ENG-SP20008-R1-GEC.pdf Markup Summary

Subject: EPC ENG Review
Page Index: 1
Date: 1/6/2021 4:13:27 PM
Author: dsdrice
Color: ■
Layer:
Space:
Page Label: [1] 1 CV_01- Grading - CV01

PCD Filing No.:
SP-20-008

HOMESTEAD NORTH AT STERLING RANCH
EARLY GRADING & EROSION CONTROL PLAN

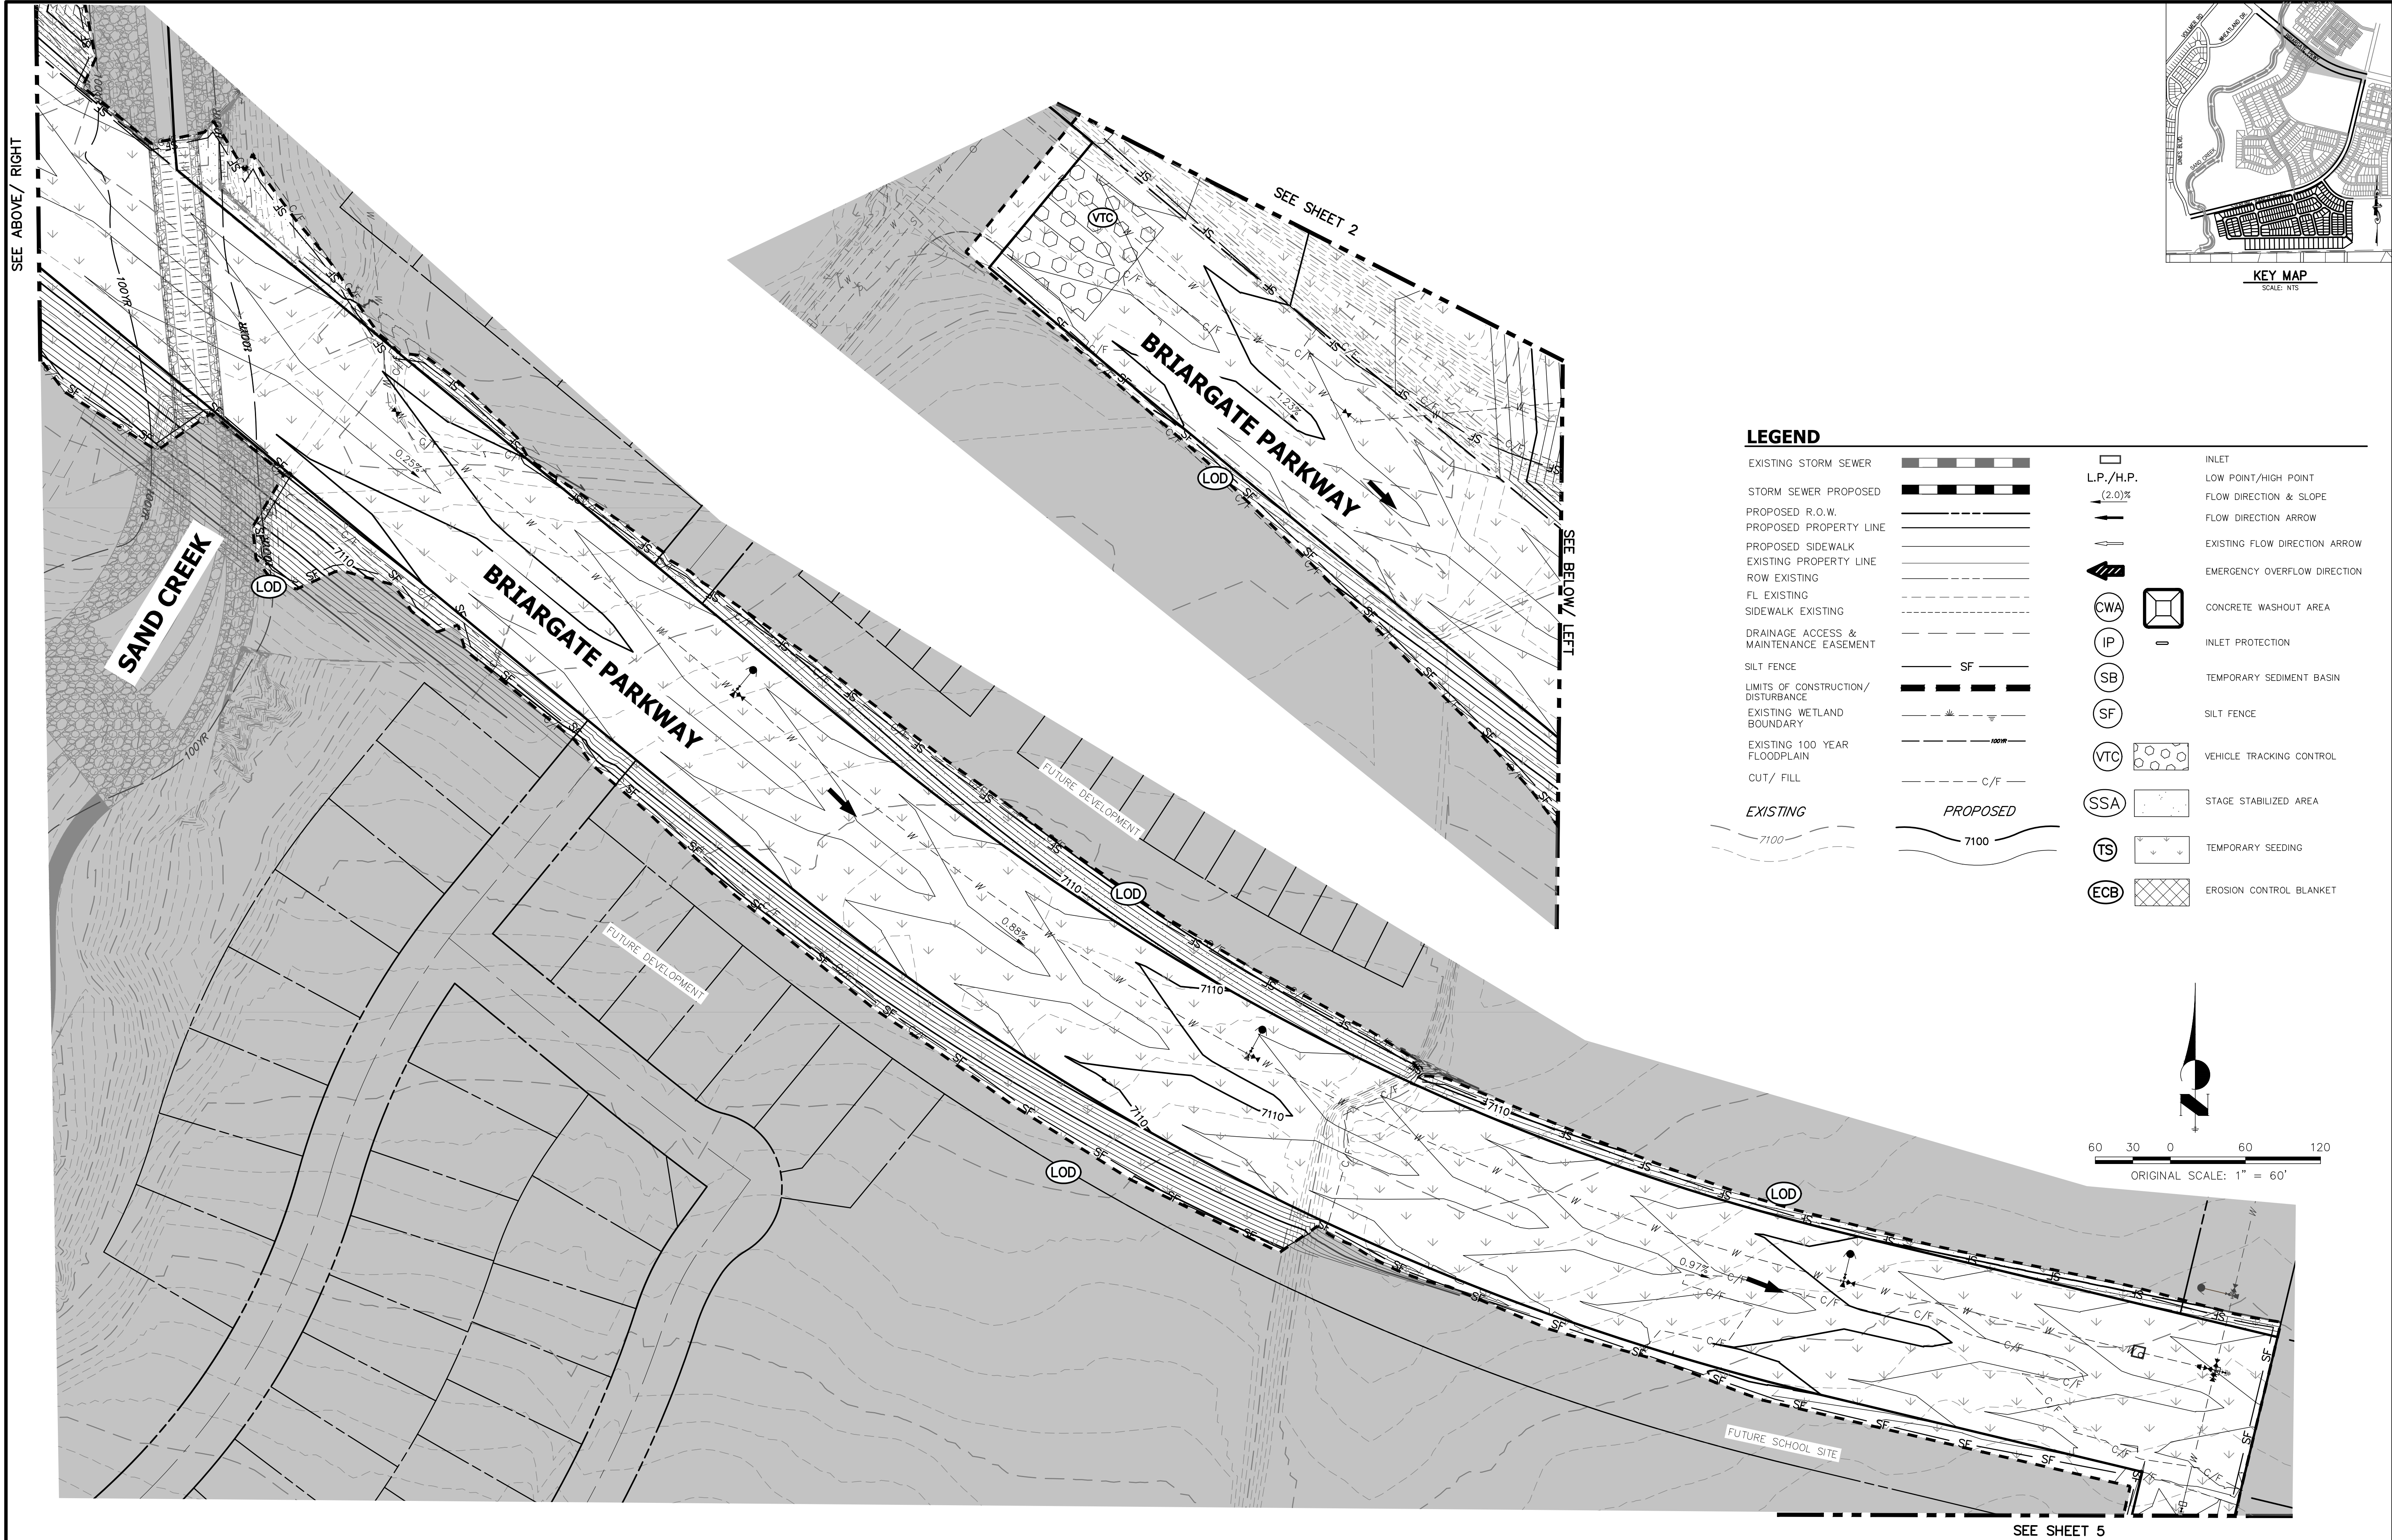
Show access road/trail grading through disturbed areas. Will retaining walls be required?

See Preliminary Plan comments about road and ROW widths

Revise to 75ft length

For SP review with EGP, remove C&G and sidewalks and just show rough cut of site and roads (line showing edge of roads is ok).

Also remove all storm lines and inlets from the Pre-development GEC plan. Provide means of conveying the runoff to the temporary sediment basin such as a temporary swale.

show riprap pad per detail. Label with dimensions on riprap area.

label adjacent subdivision/filing

label adjacent subdivision/filing

Seeding and Mulching shown in FAE, but not on GEC Plans or Legend below. Add to plans/legend if applicable or add a note explaining when/where to seed and mulch.

Also show location and label stockpile location or make a note that says location is TBD by contractor.

Checklist Item "i" - make a note of condition of existing vegetation.

add wetland and 100-yr floodplain linetypes to legend

Checklist item "e" --- show property boundary that runs through this area, as shown on Prelim Plan sht 6.

show areas of cut/fill and add lintype to Legend

Checklist Item "cc" - show existing and proposed easements.

show flow direction arrows in areas southeast of Wheatland Dr.

Show slope of steep grading (typ)

Show location of spillway per MHFD detail

label riser outlet with design details like size and orifice holes per MHFD detail

and place check dams as needed throughout swales. If used, add check dam detail to sheet 5.

HOMESTEAD NORTH AT
 STERLING RANCH
 EARLY GRADING & EROSION
 CONTROL PLAN

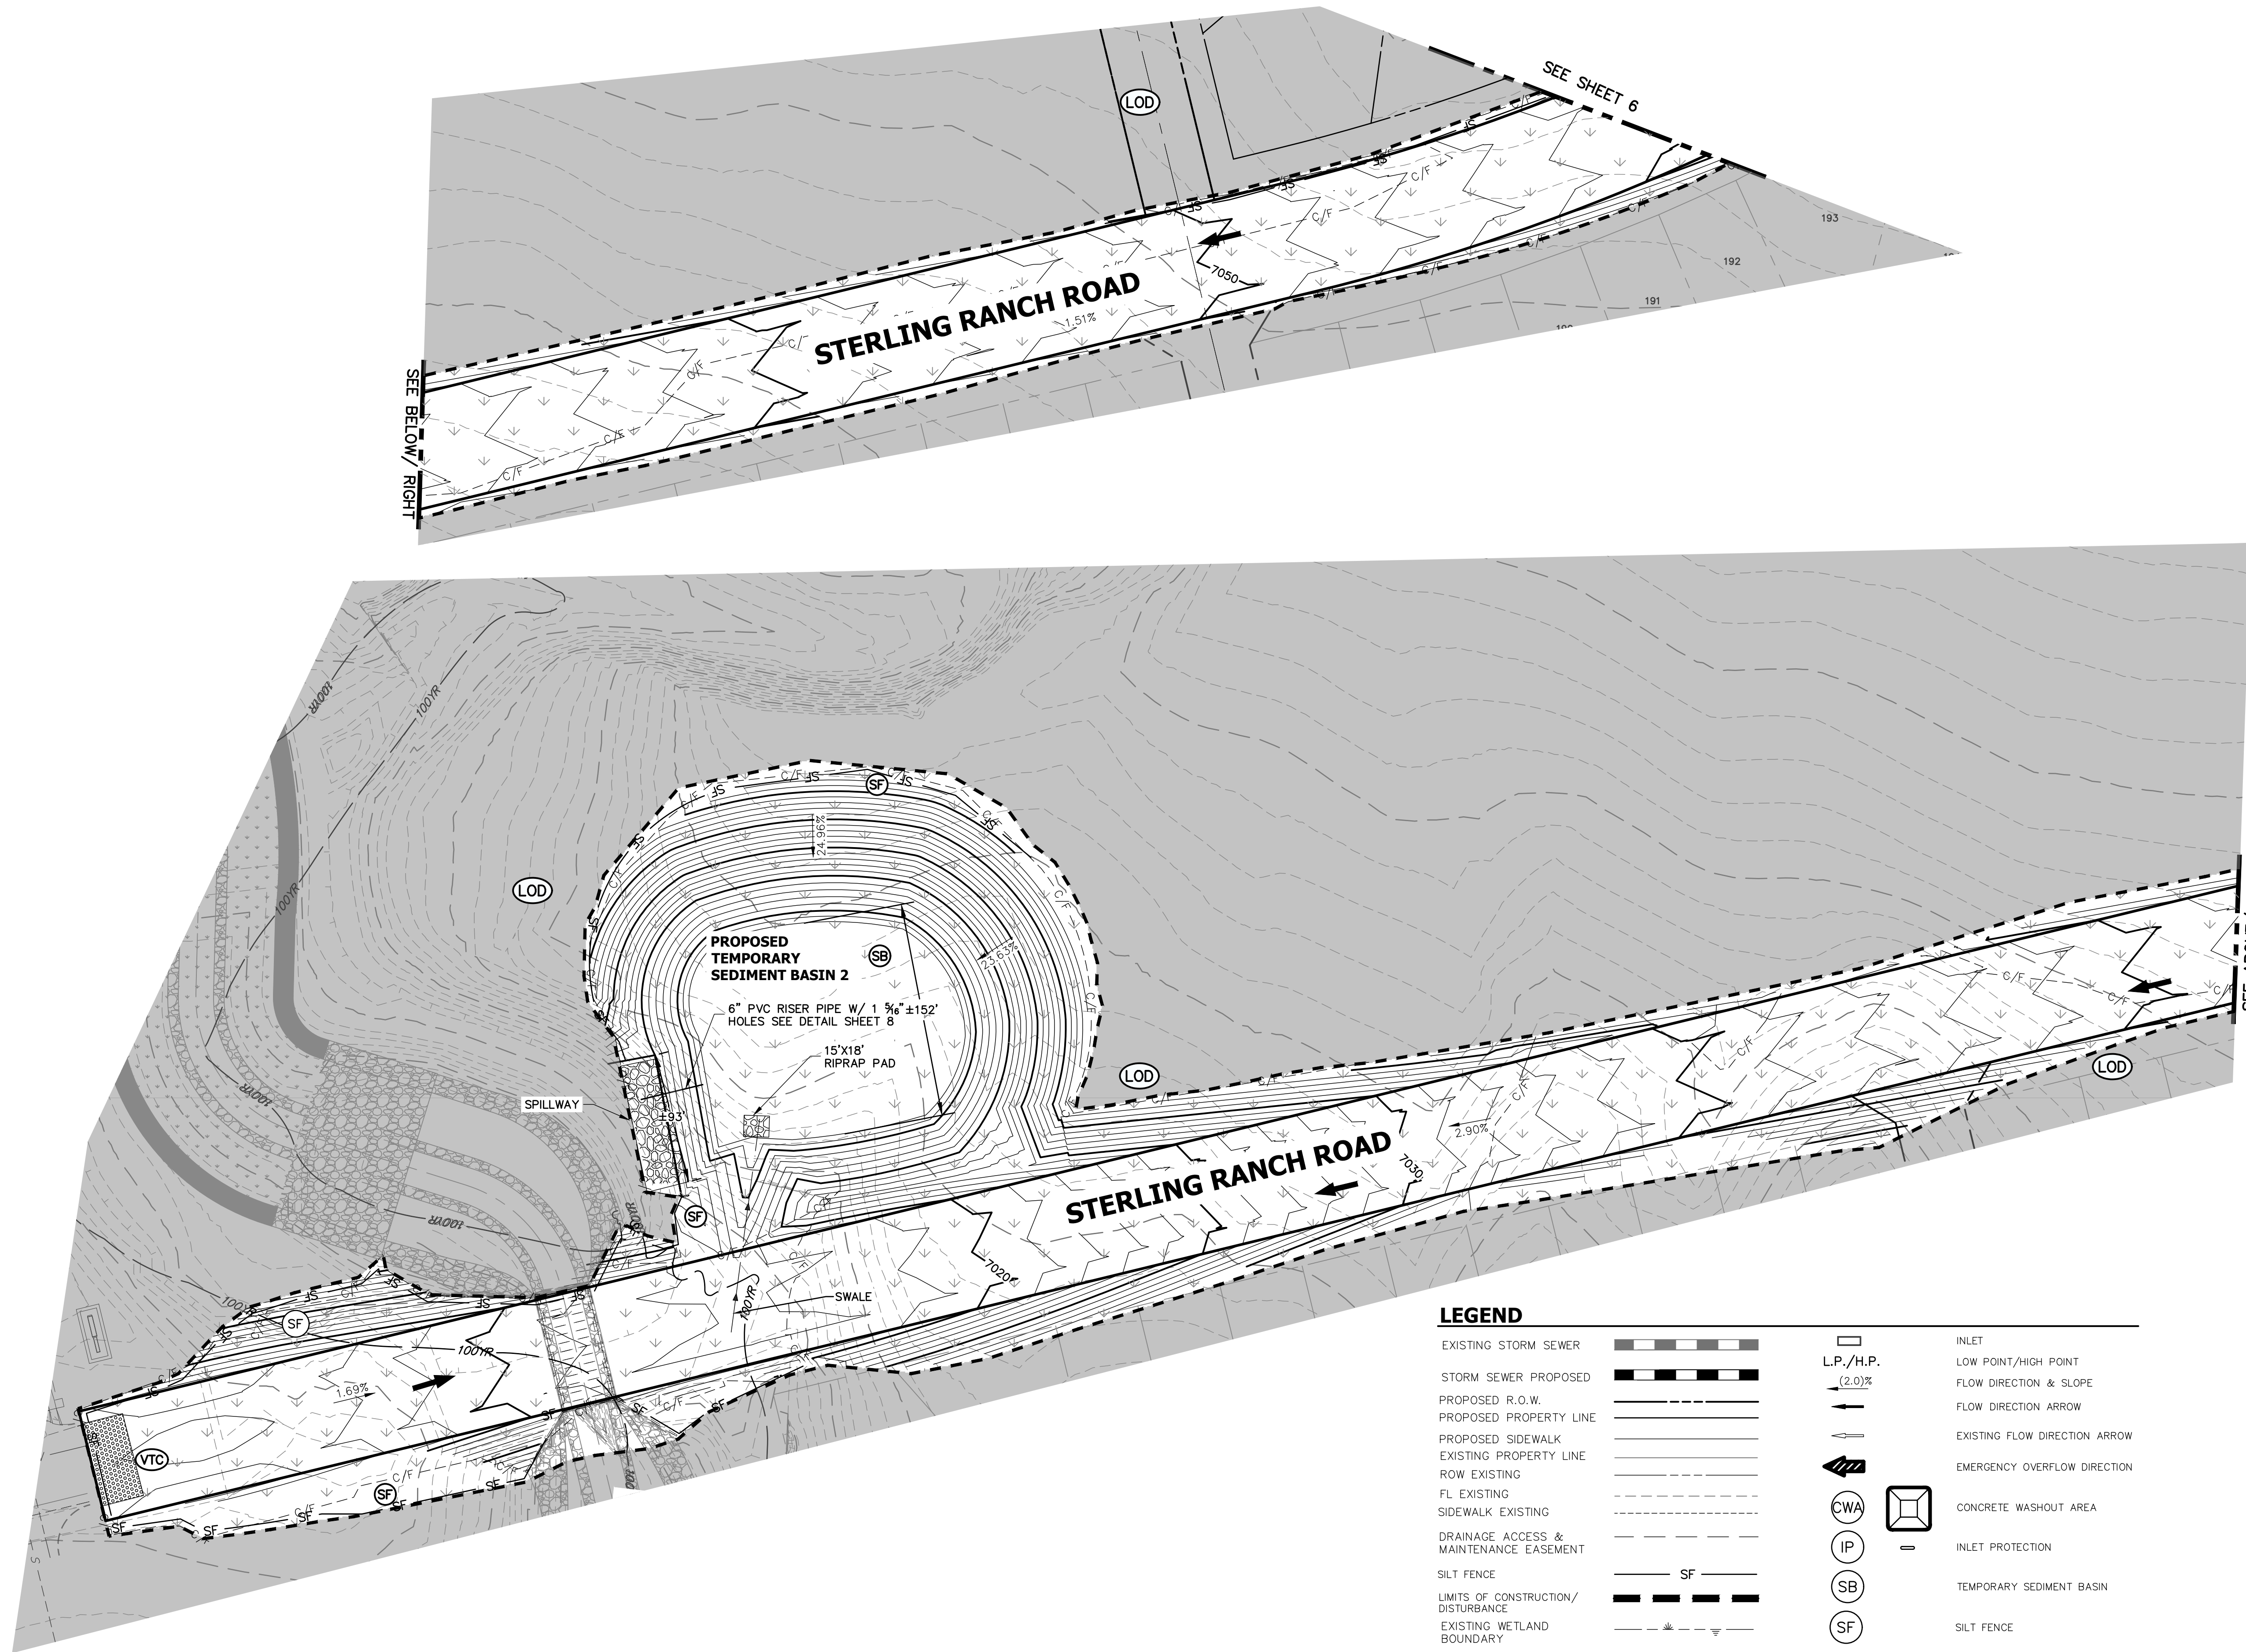
No walls for early grading. Show tie-ins to existing contours.

show tie-ins to existing contours

Is silt fence necessary? If so, it should follow contours.

label adjacent subdivision/filing

label adjacent subdivision/filing

If the same as the limits of disturbance, change to "limits of construction/ disturbance" or add "limits of disturbance" to the legend and figure
